DRB Project# 1002643 Subdivision Name TRACTS A THRU D LANDS OF PARADISE HEIGHTS, LLC

SURV-TEK INC agent(s) for PARADISE HEIGHTS LLC request(s) the above action(s) for all or a portion of Tract(s) A-D, **LANDS OF PARADISE HEIGHTS**, zoned R-1, located on DOUGLAS AVE NW, between WESTSIDE BLVD NW and BROOKLINE BLVD NW containing approximately 42 acre(s). (A-10)

**DEVELOPMENT REVIEW BOARD--SPEED MEMO**

CITY OF ALBUQUERQUE  
PLANNING DEPARTMENT  
DEVELOPMENT REVIEW BOARD

**BULK LAND PLAT OF
TRACTS A THRU D
LANDS OF PARADISE
HEIGHTS, L.L.C.**

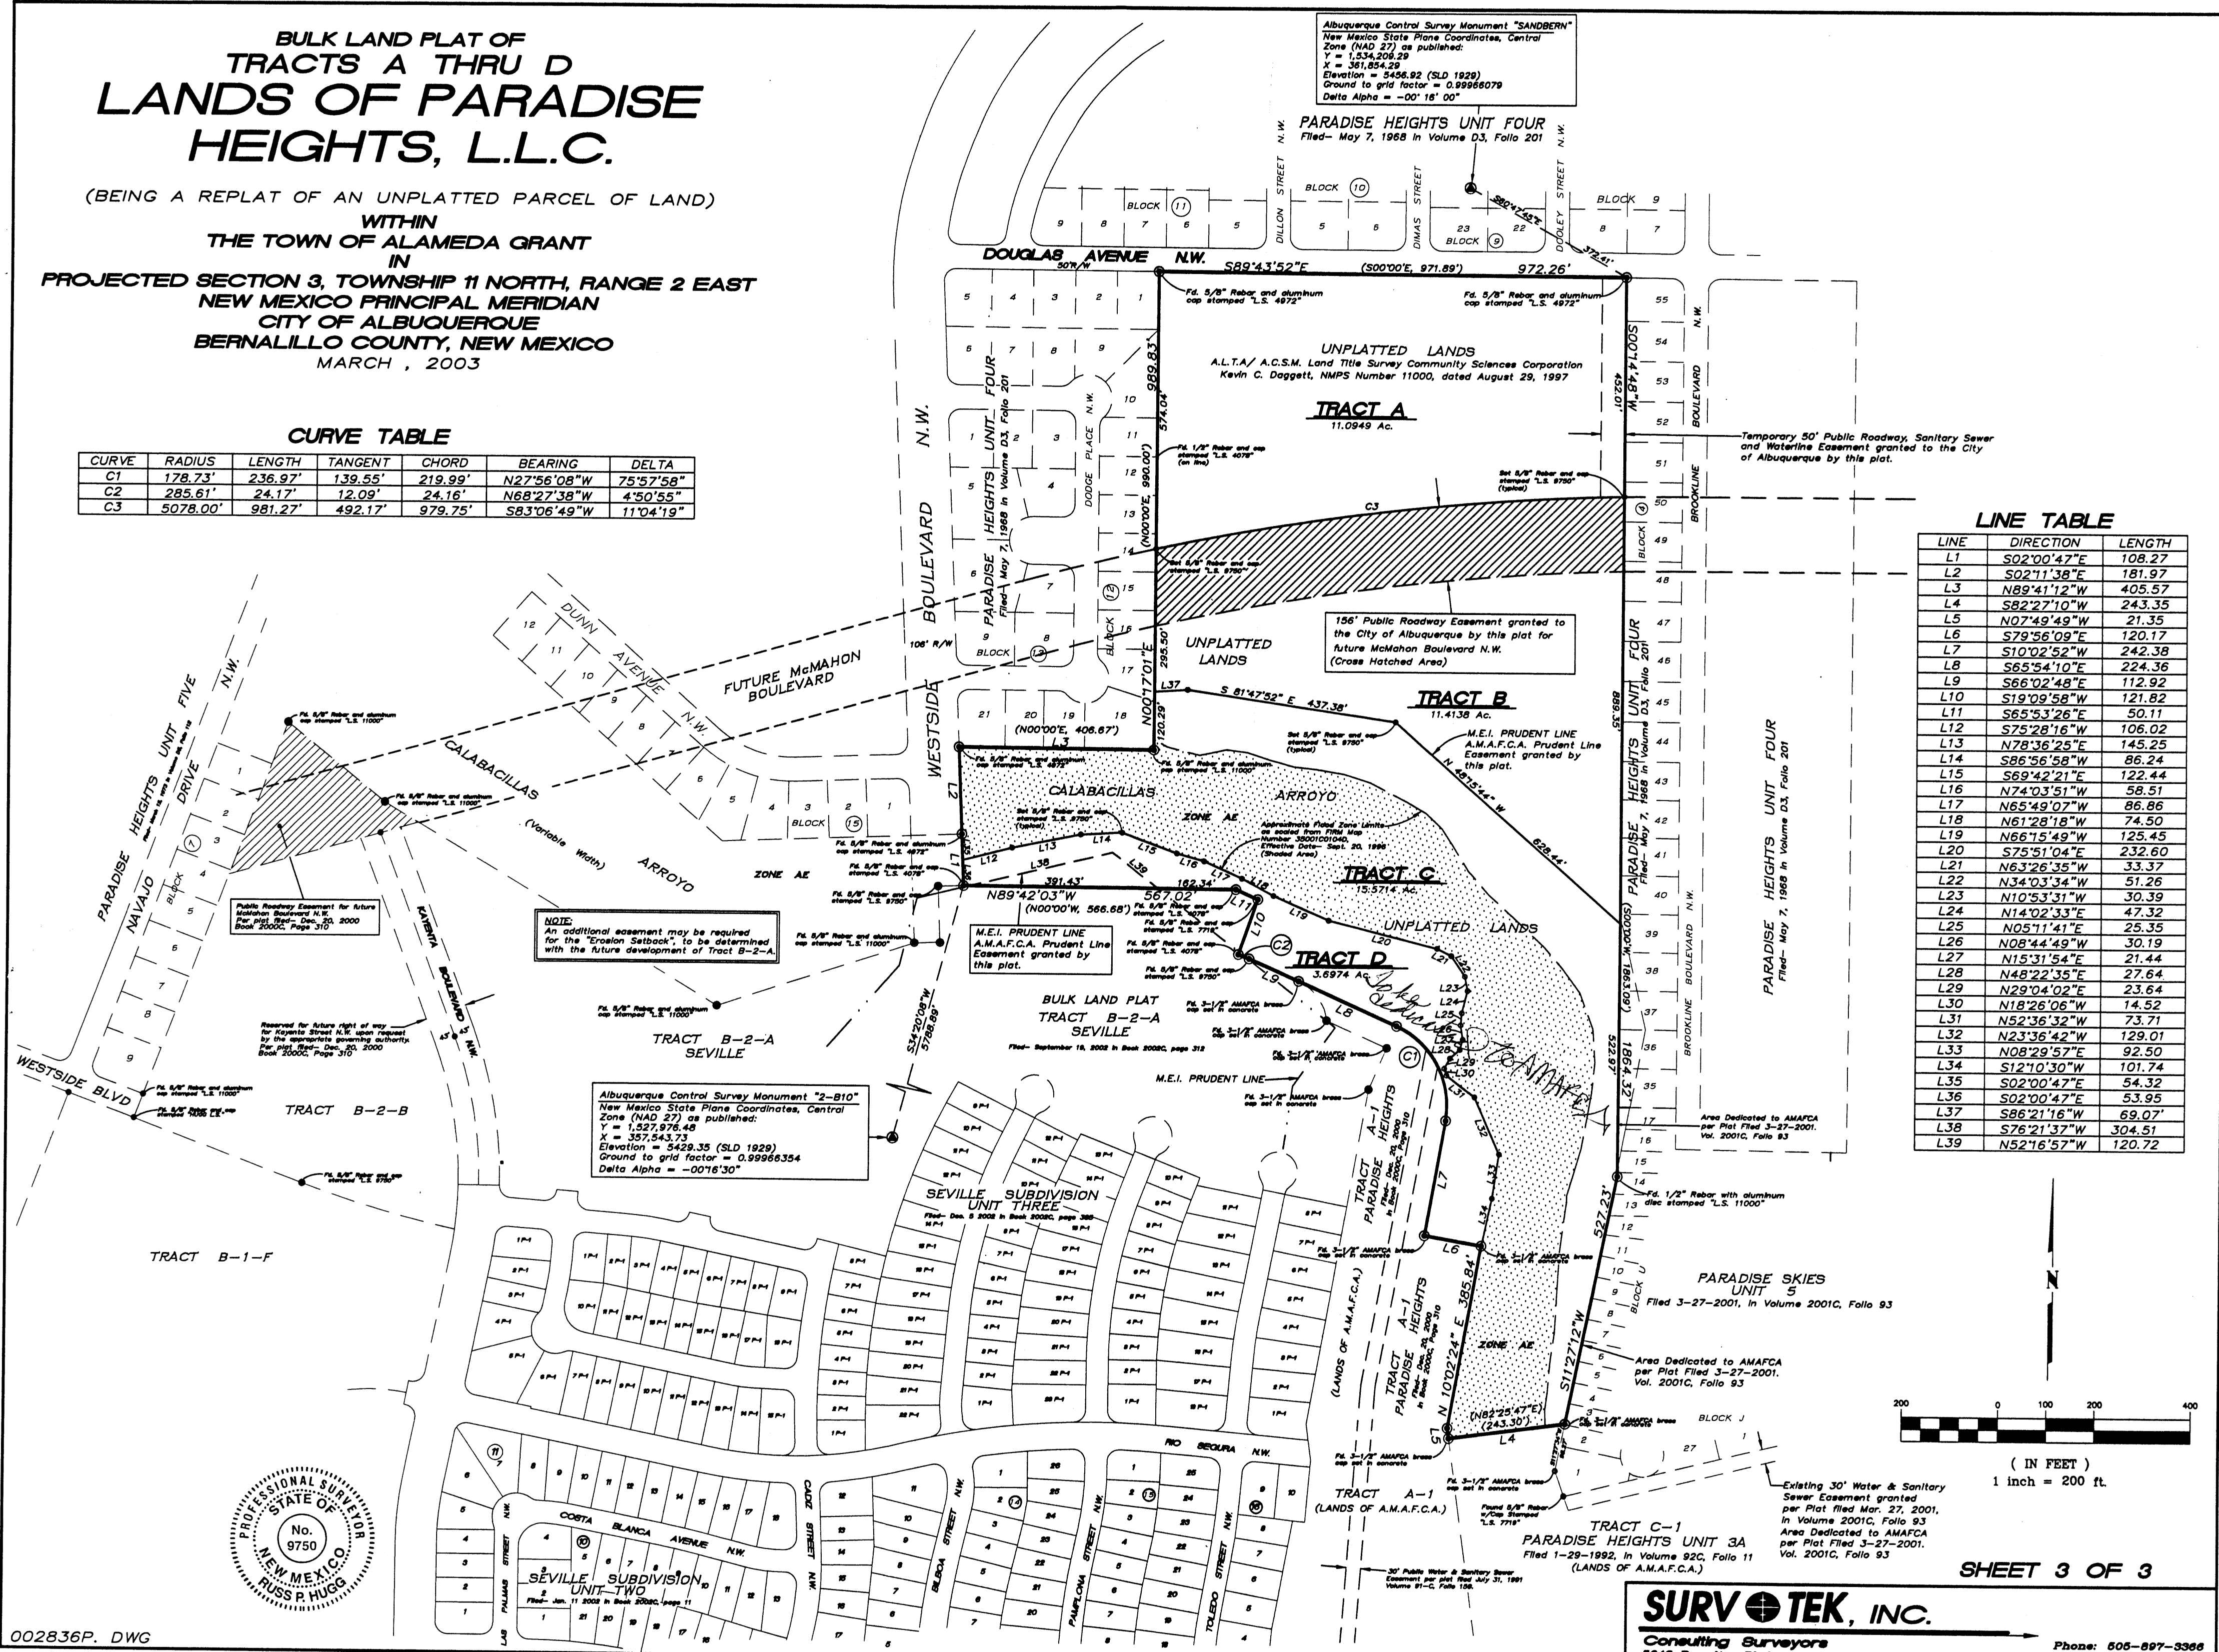
The Public Roadway easements for McMahon needs to be granted with this plat. Does this alignment follow the McMahon Corridor Plan? Access needs to be provided to all lots. Some tracts do not appear to meet the lot size requirements for bulk land variance.

No objection to Bulk Land Variance. Easement across Tract A must have dedication language.
